# GRADING AND EROSION CONTROL PLAN FOX RUN NATURE CENTER

EPC STORMWATER REVIEW COMMENTS  
IN ORANGE BOXES WITH BLACK TEXT

EL PASO COUNTY  
UNINCORPORATED  
FOX RUN NATURE CENTER  
2108 STELLA DRIVE  
COVER SHEET & NOTES

GEC-3

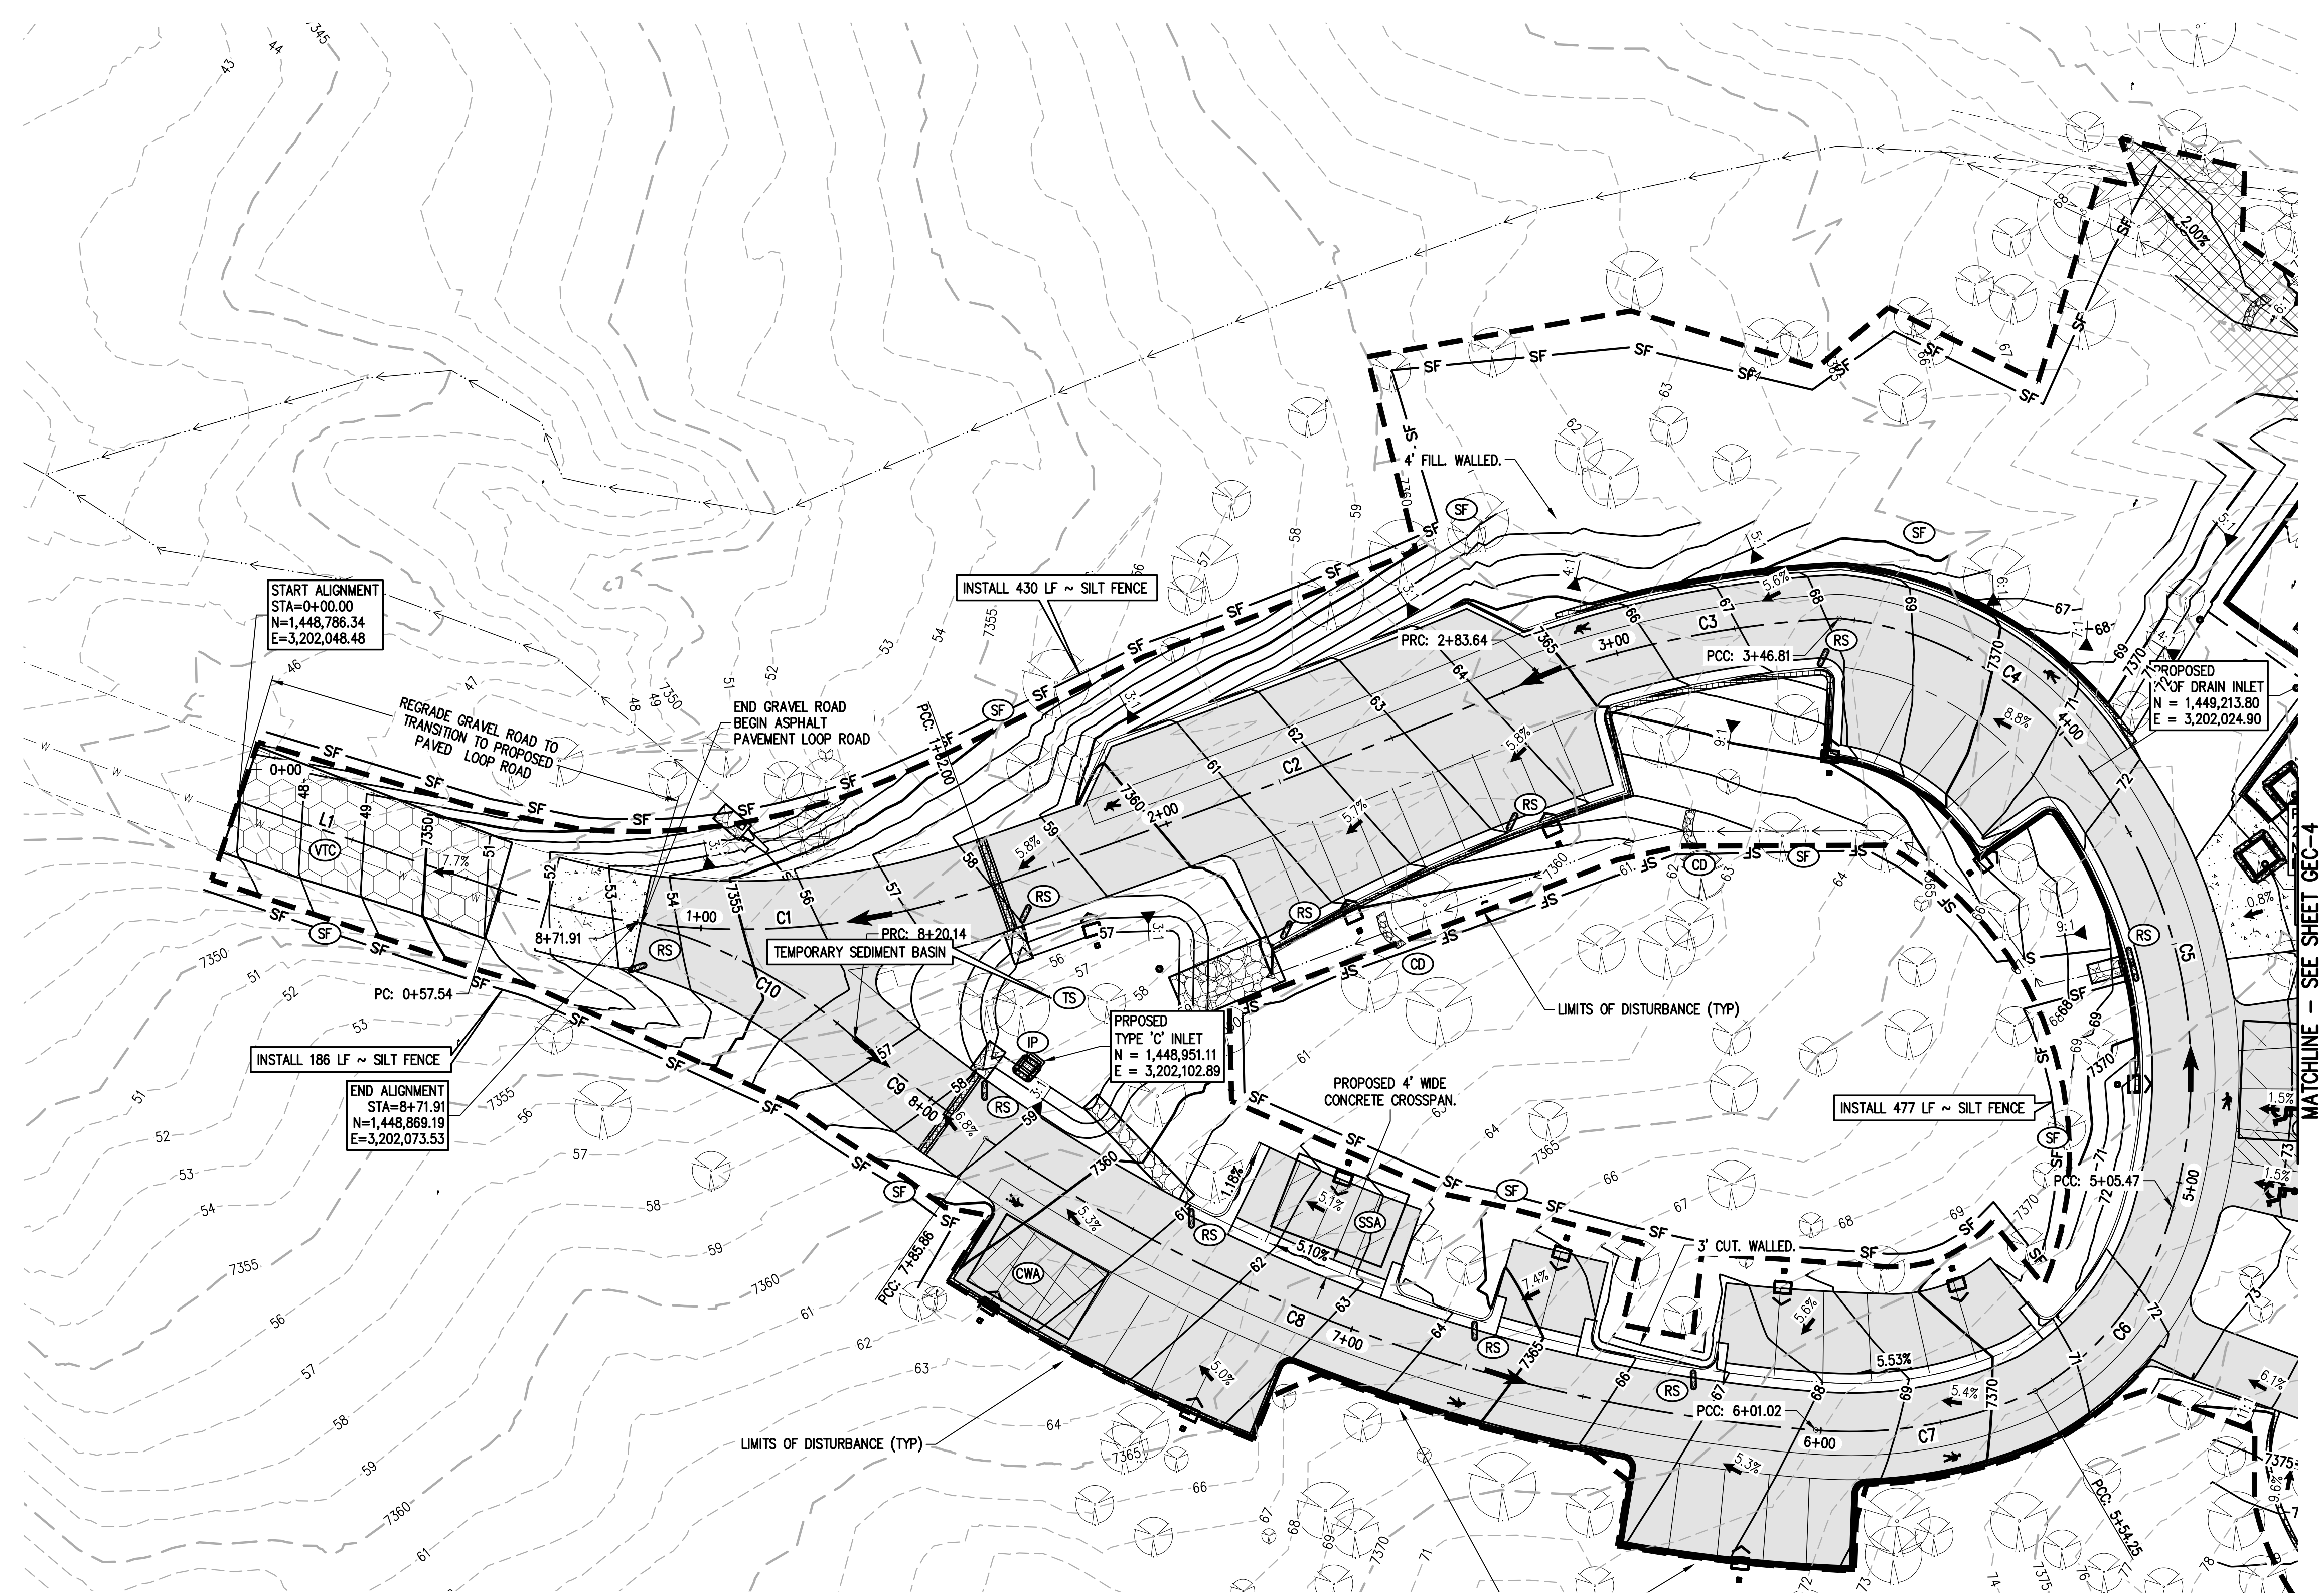
GEC Checklist Item "t" - state condition of existing vegetation.

GEC Checklist Item "p" - delineate areas of cut and fill.

GEC Checklist Item "u" - show location of staging/storage areas and stockpiles and if outside of existing LOD, add them to the LOD.
